# Permit Inspections Harnett County

**Permit Number: SFD2206-0057**

Description: **57x57 sfd, 4 beds**

Site Address: **320 PRINCE PLACE DR**

**ROOF FRAMING PLAN**  
 SCALE: .....1/4" = 1'-0"

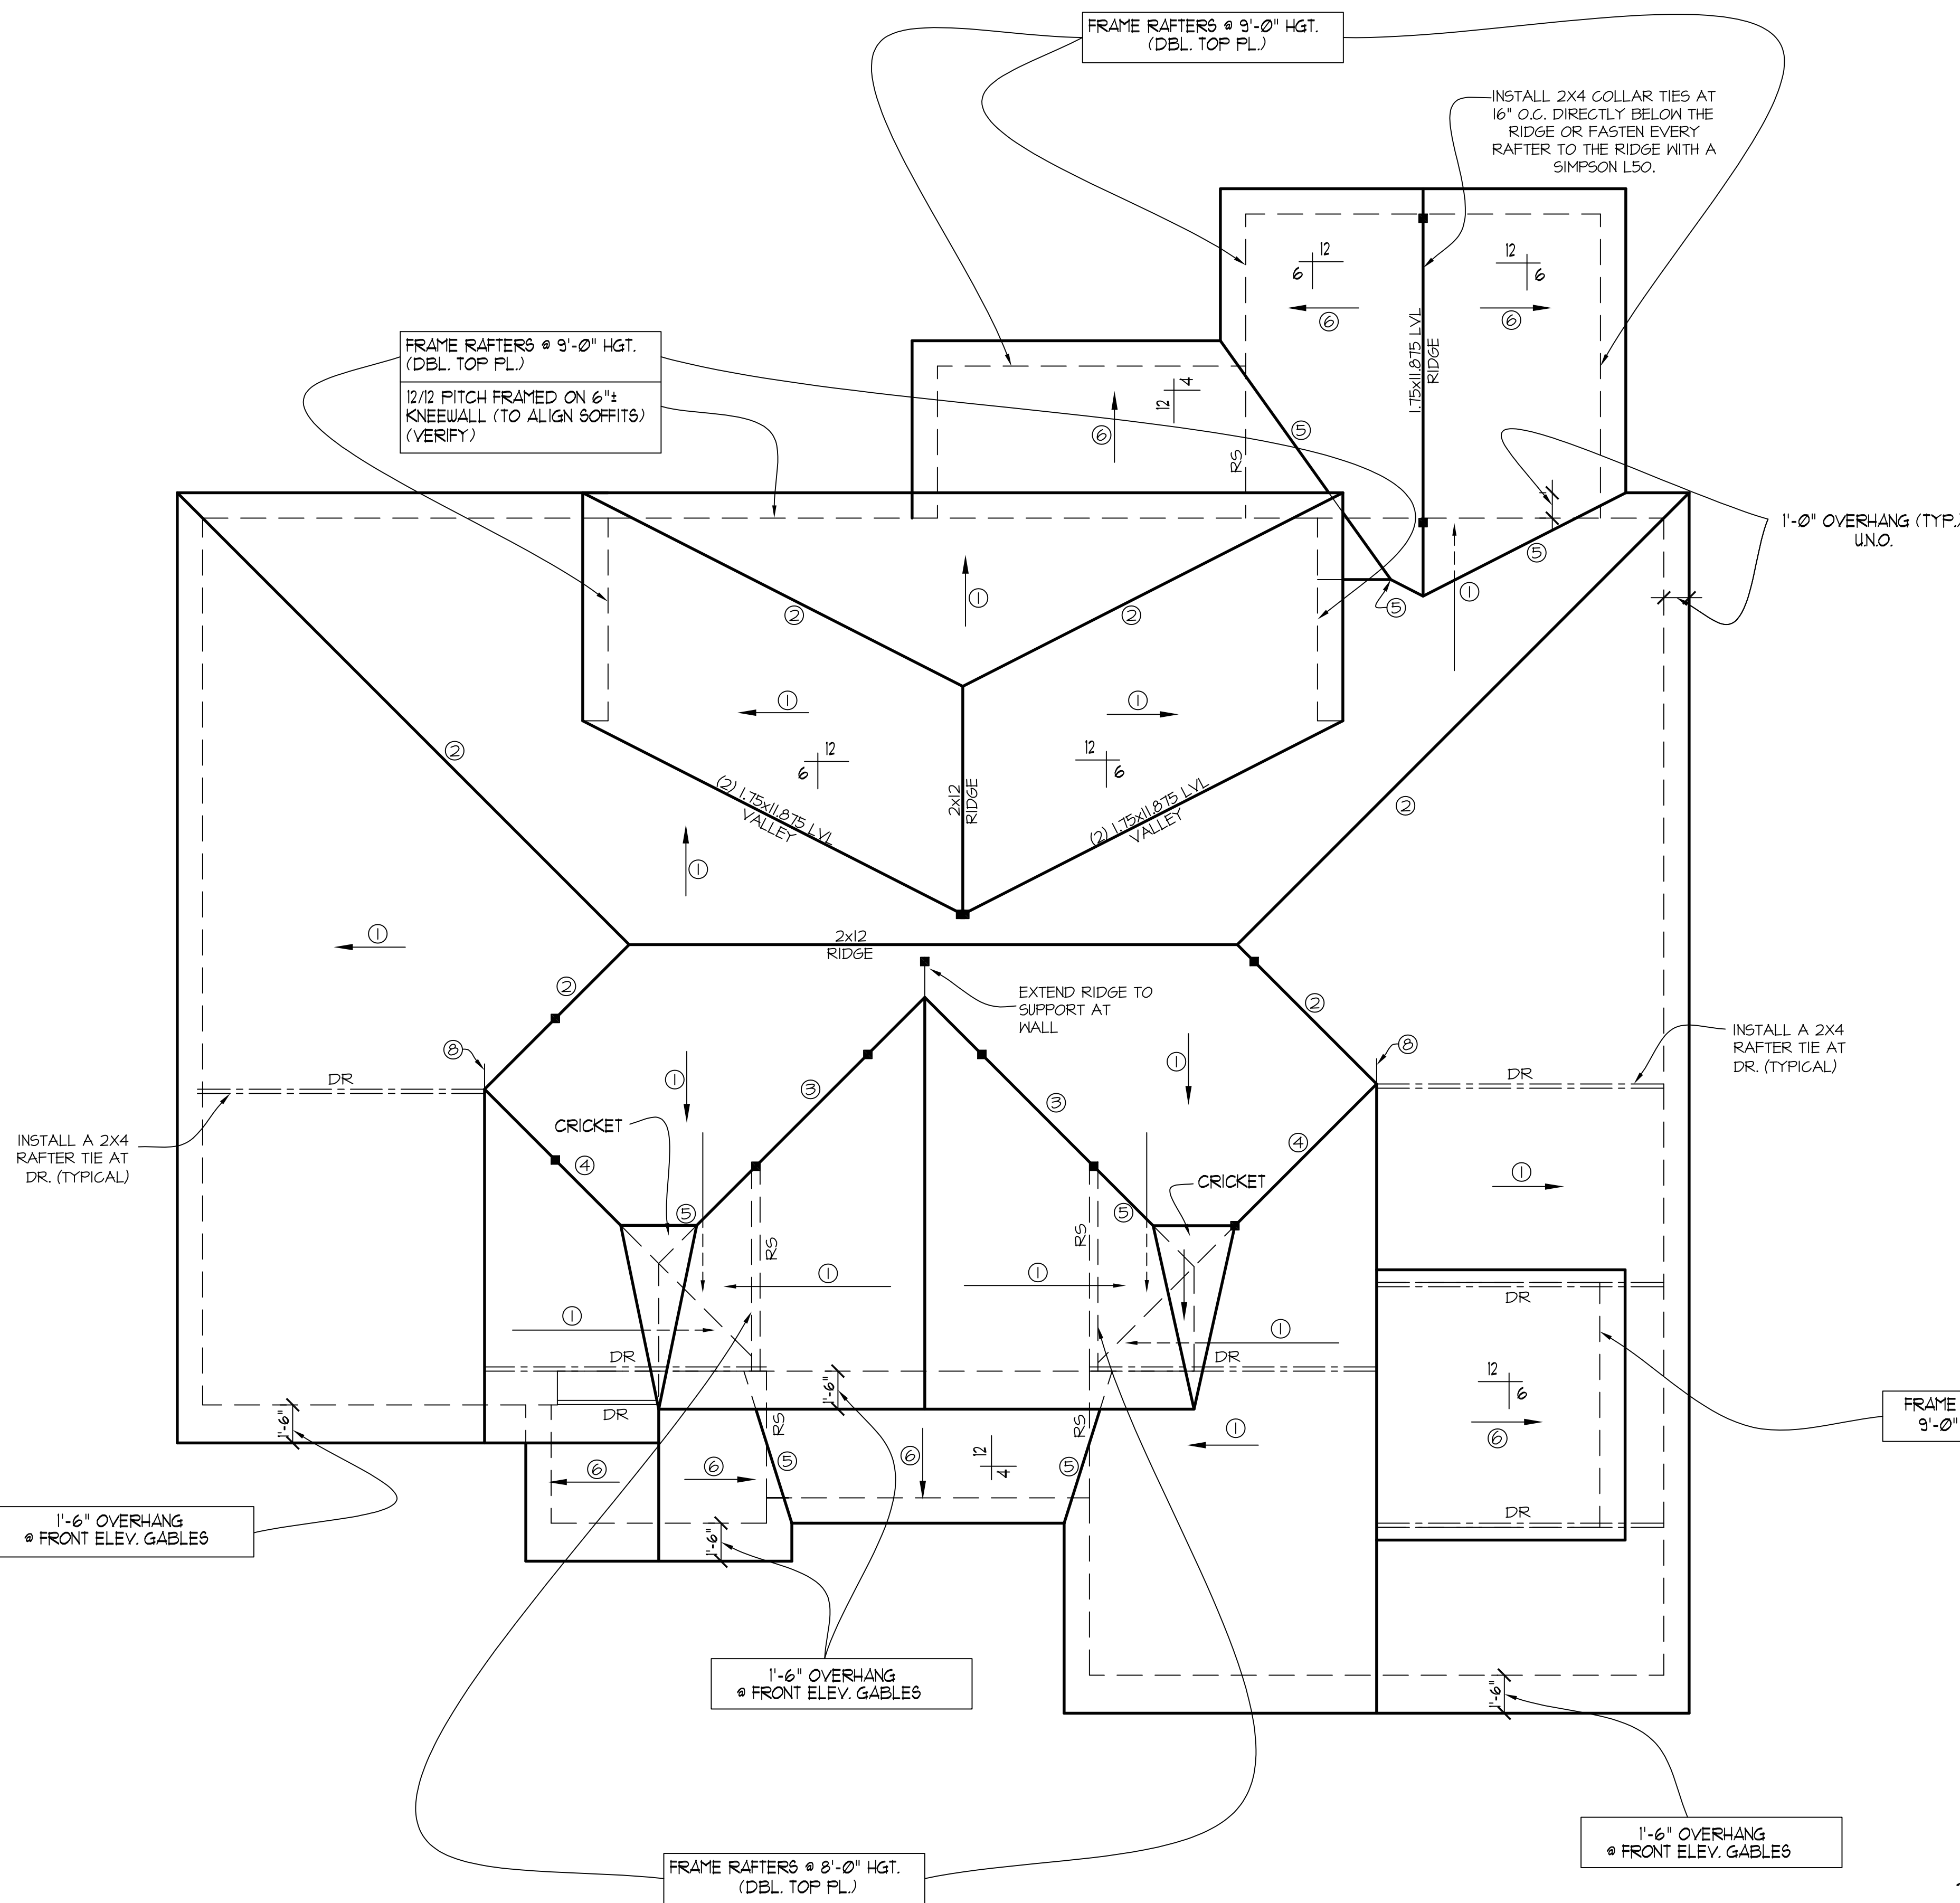
1. Missing htt4 hold down at portal framing per plan. 2. Missing cs16 strapping at portal framing. 3. Missing hurricane clips on 2 rafters above rear door. 4. 3 stud column upstairs right rear bedroom closet area. 5. Plan states knee wall height in bonus to be 4' +/-.
